East Anglia TWO Offshore Windfarm

Appendix 28.1

Seascape, Landscape and Visual Impact Assessment Consultation Responses

Applicant: East Anglia TWO Limited
Document Reference: 6.3.28.1
SPR Reference EA2-DWF-ENV-REP-IBR-000920_001 Rev 01
Pursuant to APFP Regulation: 5(2)(a)

Drawing file: EN010078 / EN010078-001371-6.2.28.55 EA2 ES Figure 28.55 Viewpoint 2 PEIR and ES Layout Comparison.pdf

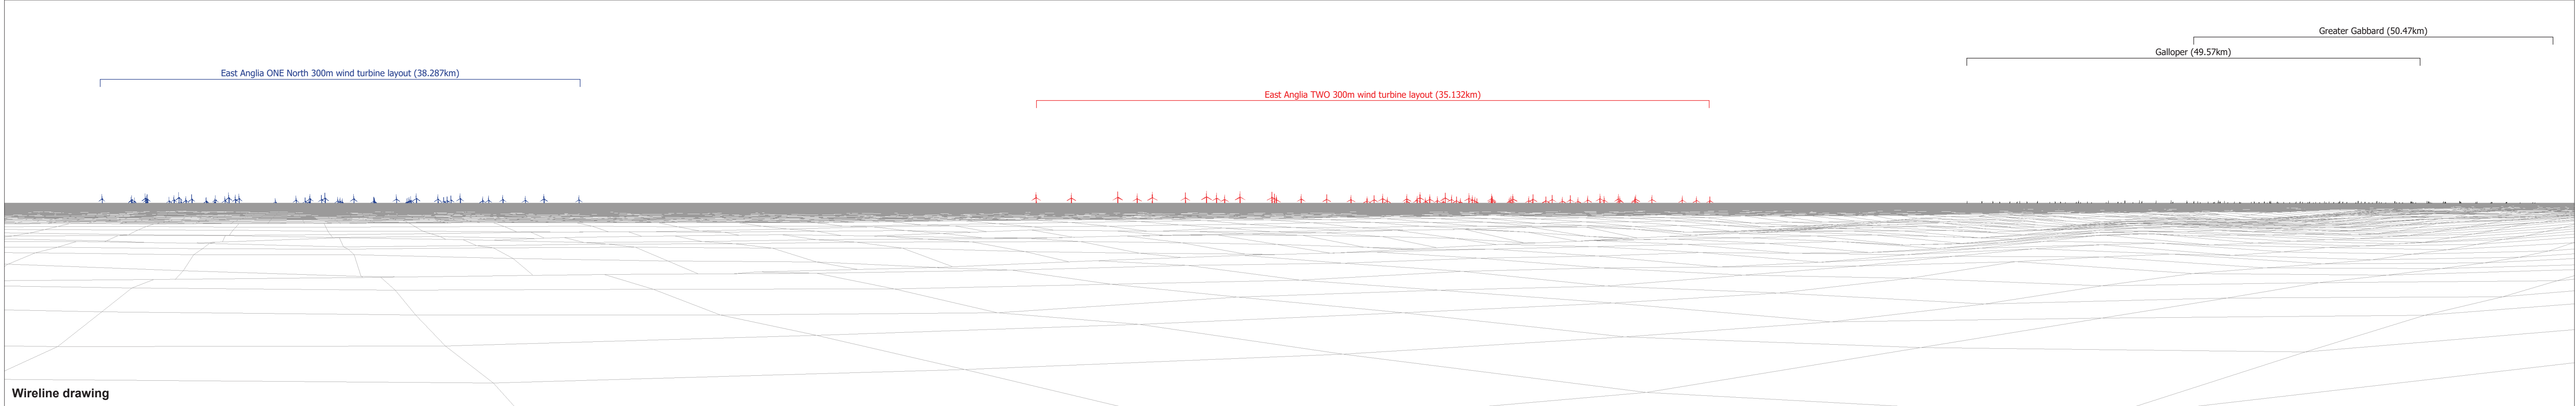
Consultee	Date/ Document	Comment	Response / where addressed in the ES
	Section 42 Consultation Response	Suffolk Coast & Heaths AONB, the boundary of the designation should be shown on landscape character, Zone of Theoretical Visibility (ZTV), including cumulative ZTVs, and viewpoint maps to enable the reader to identify those landscape areas and viewpoints, which are relevant to the AONB.	shows the AONB on the ZTV. Figure 28.21d shows it cumulatively with East Anglia ONE North. AONB shown in viewpoint location map Figures 28.25-28.54 .
Suffolk Coast and Heath AONB Partnership	25/03/2019 Section 42 Consultation Response	Whilst it is recognised that viewpoints have been selected through consultation with key parties, there are a number of Landscape Character Types (LCTs) where landscape effects are identified but no representative viewpoint is provided. Viewpoints for example from North Warren (LCT 7d) or from river flood defence embankments adjacent to the River Ore (LCT 6e) would be informative.	Representative and illustrative viewpoints were selected and agreed in consultation with ETG, covering regular and representative locations along the AONB coastline. There are two viewpoints within 2km of North Warren at Aldeburgh and Thorpeness (Viewpoint 12 & 13). Although further viewpoints are not required to form a judgement on the likely significant effects of the proposed East Anglia TWO and East Anglia ONE North projects), illustrative wireline viewpoints have been provided from North Warren (Figure 28.54) and River Ore (Figure 28.55).
